CITY OF ALBUQUERQUE

January 28, 2014

**RE: McKinley Middle School
Grading and Drainage Plan
Engineers Stamp Date 11/26/13 (G17D019)**

GRADING PLAN

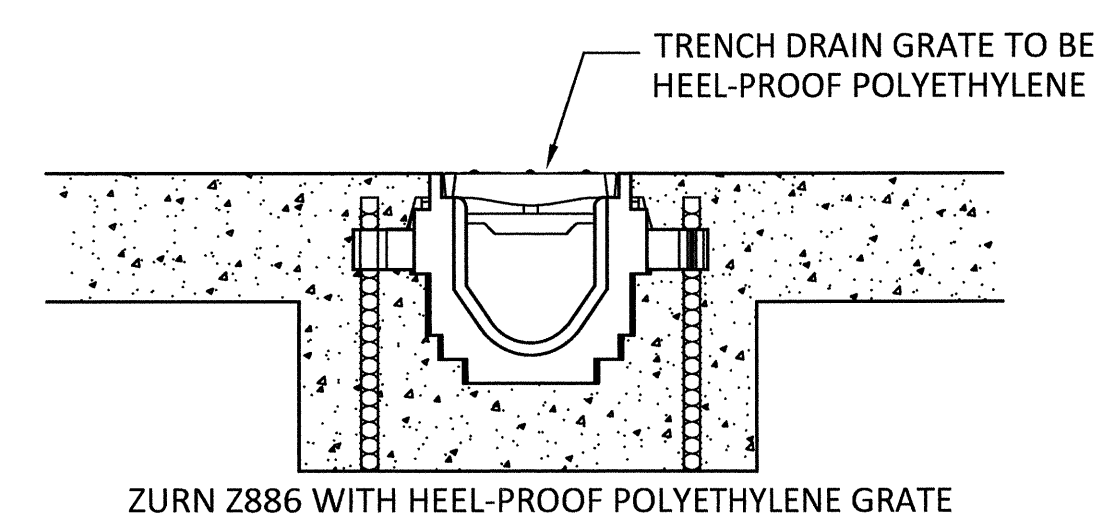
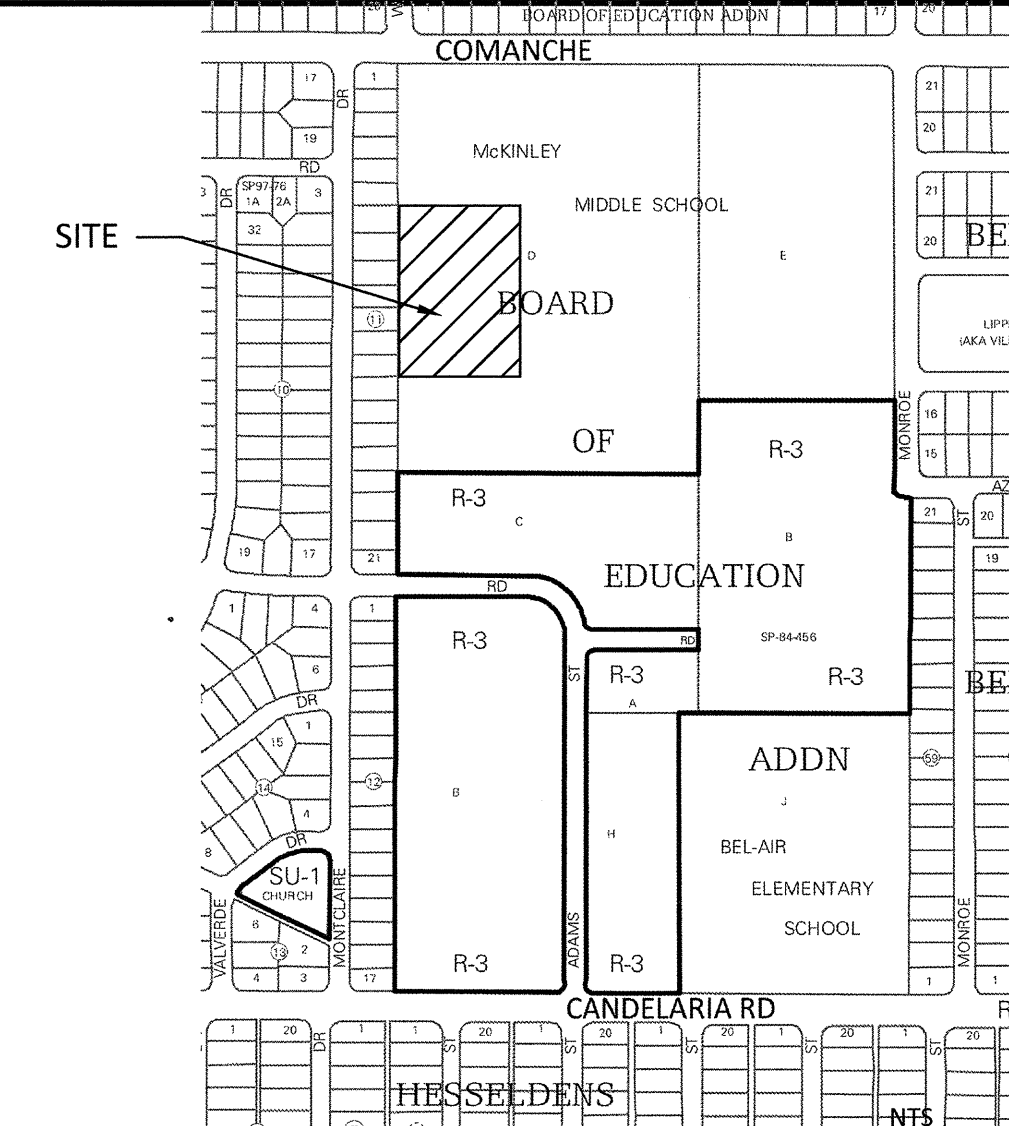
- Provide additional grades (spot elevations or contours) to the west of this site so that it is evident this area will drain toward Comanche.
- The inverts are doubled and not legible, rewrite.
- How are flows leaving the site, via a sidewalk culvert or through the access road in the parking lot?
- Where is the depressed landscaped area mentioned in the narrative?
- What are the portable buildings finished floor elevations?
